25 May 2015

Application by Highways England for an Order Granting Development Consent for the A14 Cambridge to Huntingdon Improvement Scheme

I write to give further observations and objections to part of the above scheme following your letter of 21 May 2015. My comments are concerned solely with that section under consideration regarding access to Huntingdon town centre and the Public Notices affixed to structures in the vicinity of the A14 viaduct over the railway and the B1514 Brampton Road.

**MILL COMMON LINK
WORK NO. 36 - WORKS PLANS SHEET NO. 29**

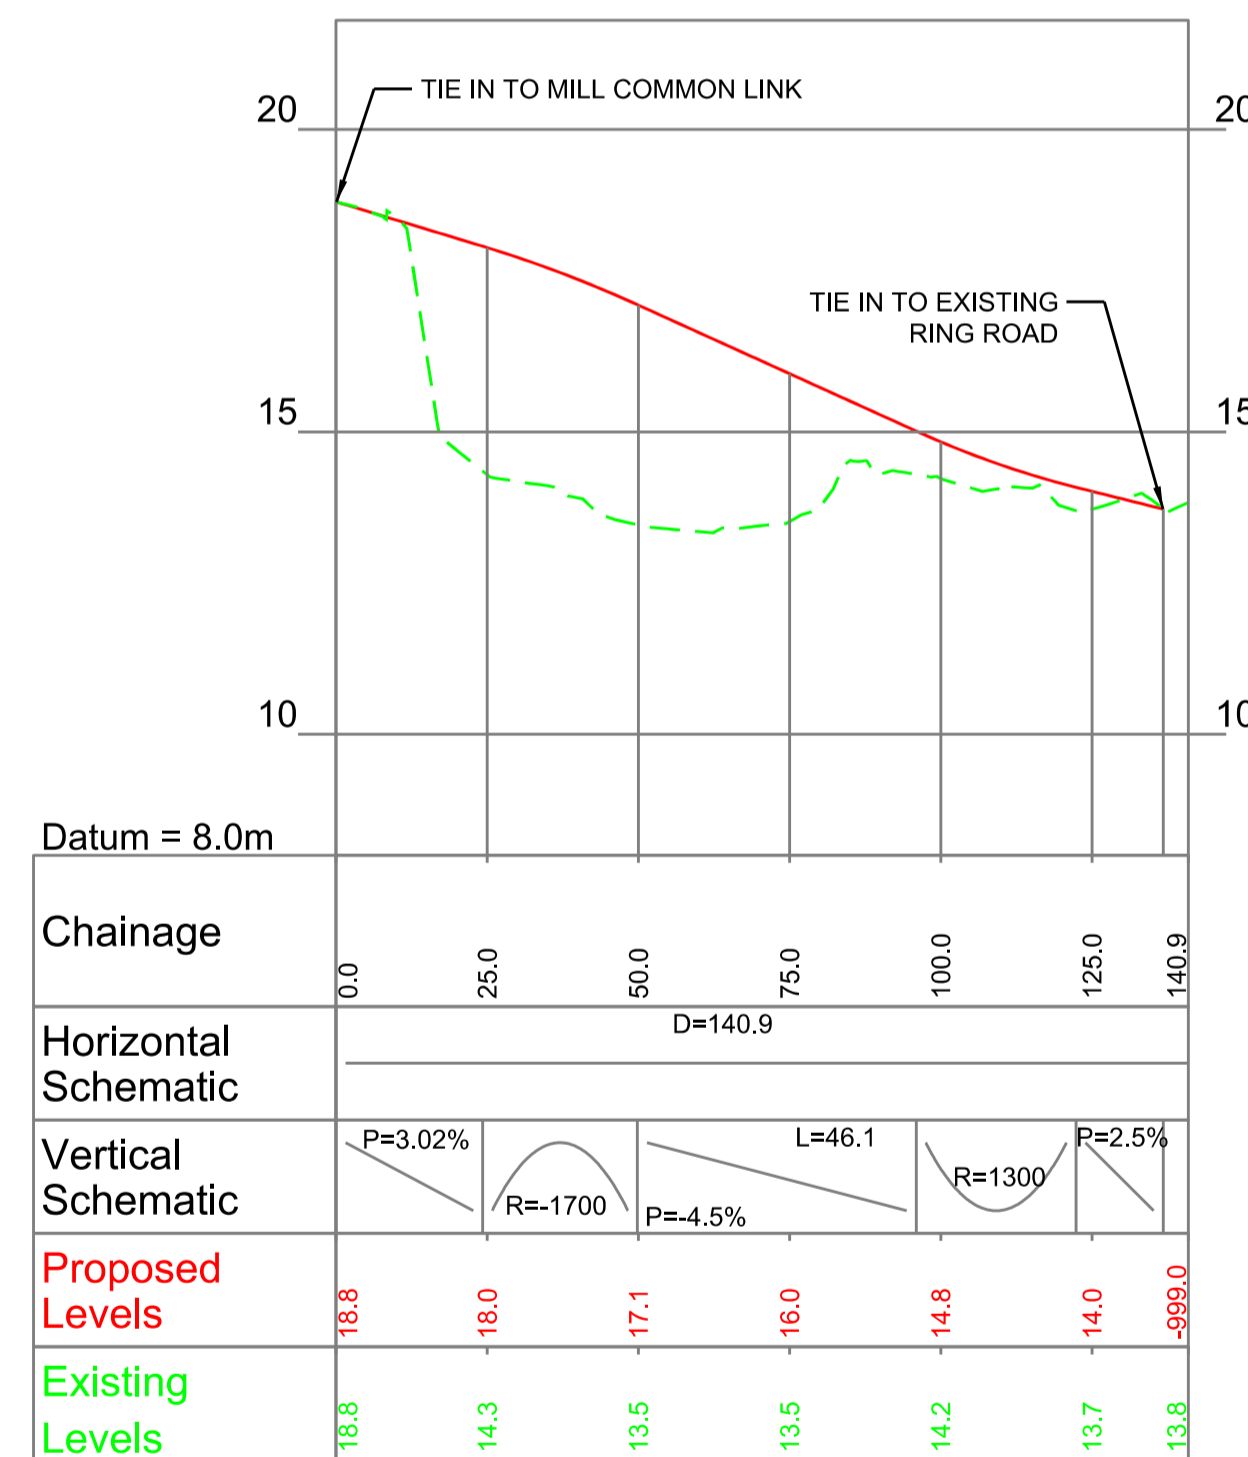
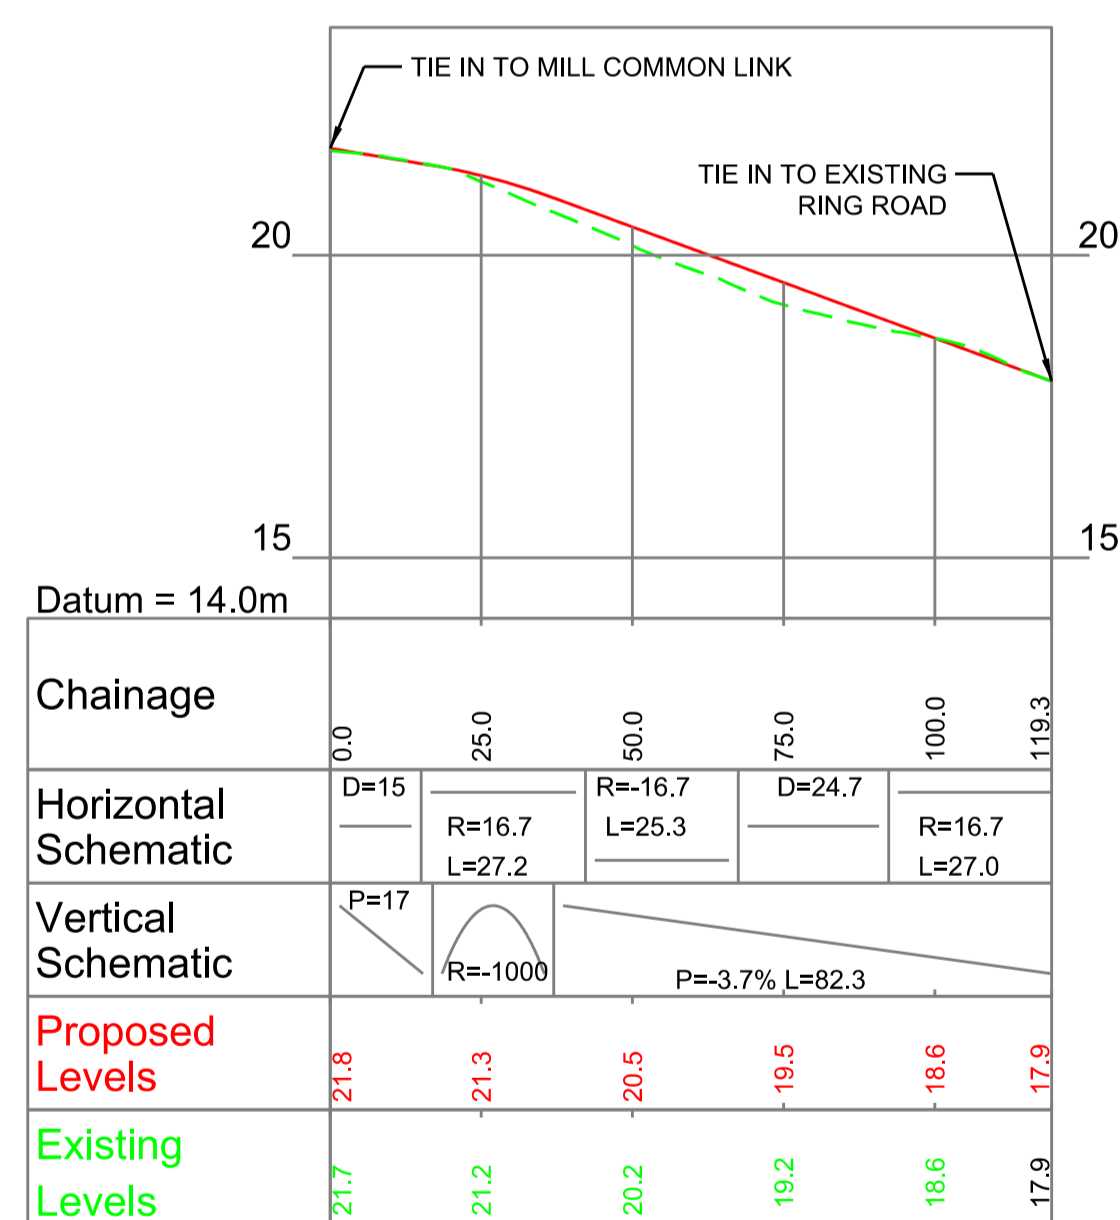
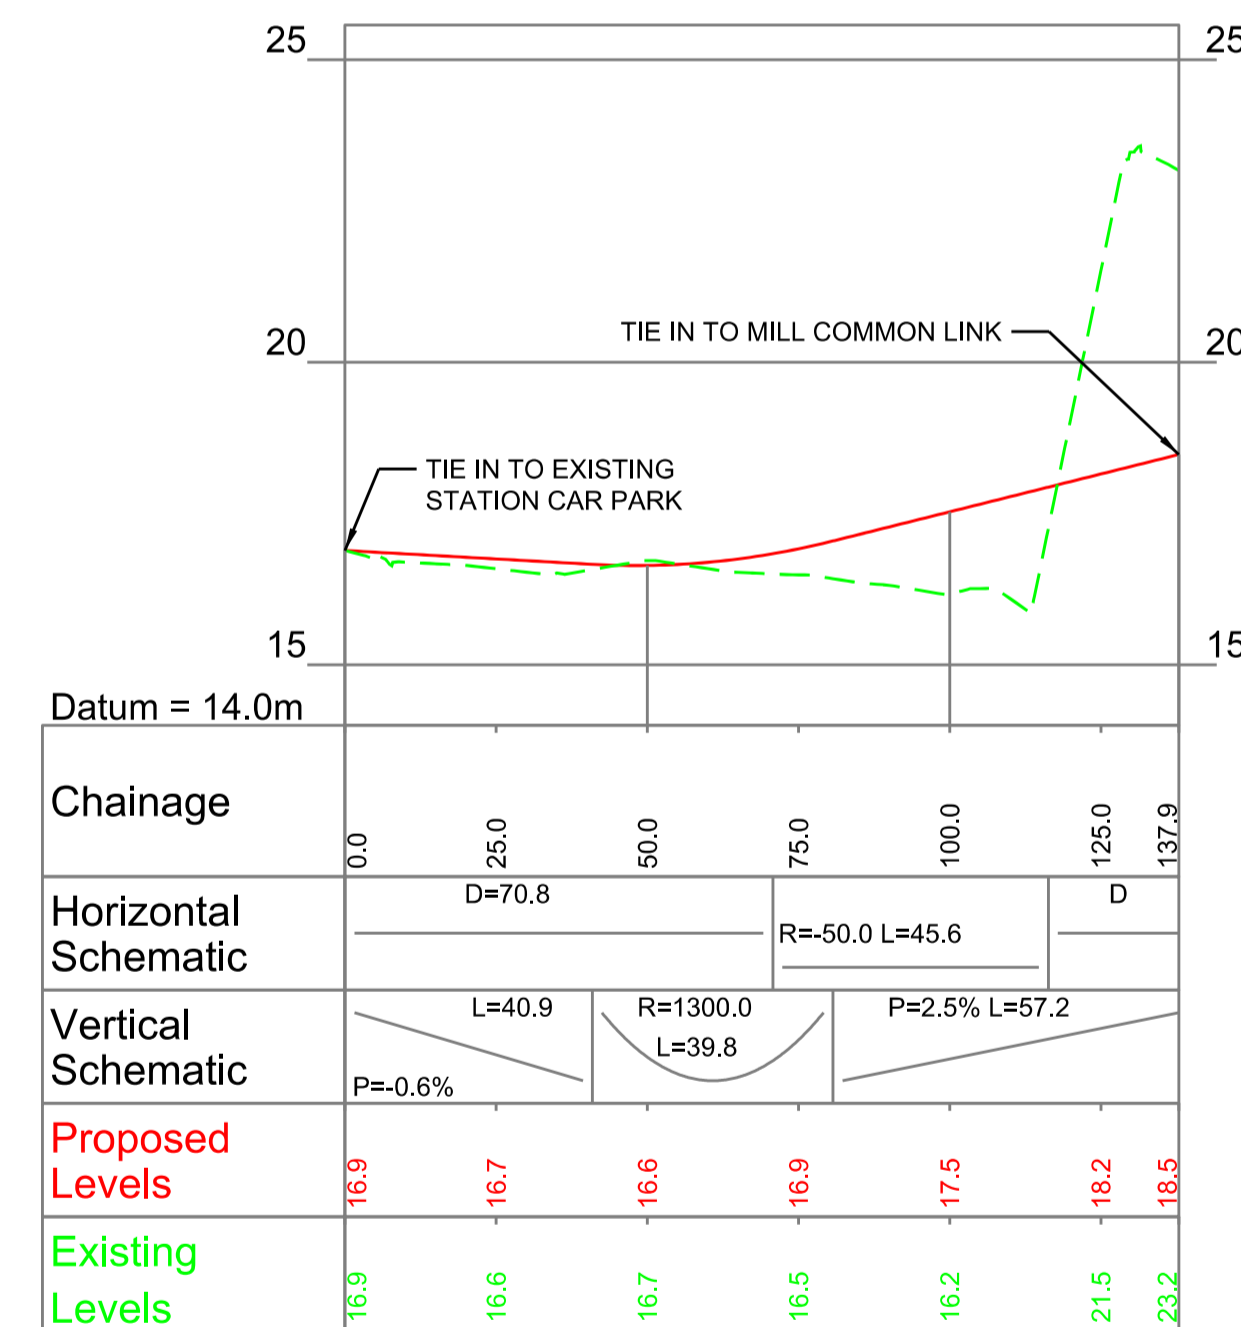
The link between the A14 and Mill Common will have a neutral effect in terms of traffic volume for those vehicles currently using the B1044 through Godmanchester. All Huntingdon bound traffic from both routes will join at Mill Common, but the congestion along the B1044 in Godmanchester will be relieved by the proposals.

3. As proposal 2 but with a link into the Huntingdon town centre ring road at Mill Common. This link should be given priority direction at the junction with the former A14. In this case, the west bound height and weight restrictions would apply immediately west of the junction with the former A14.

5. As proposal 4 but with the link from the Godmanchester interchange to Mill Common retained.
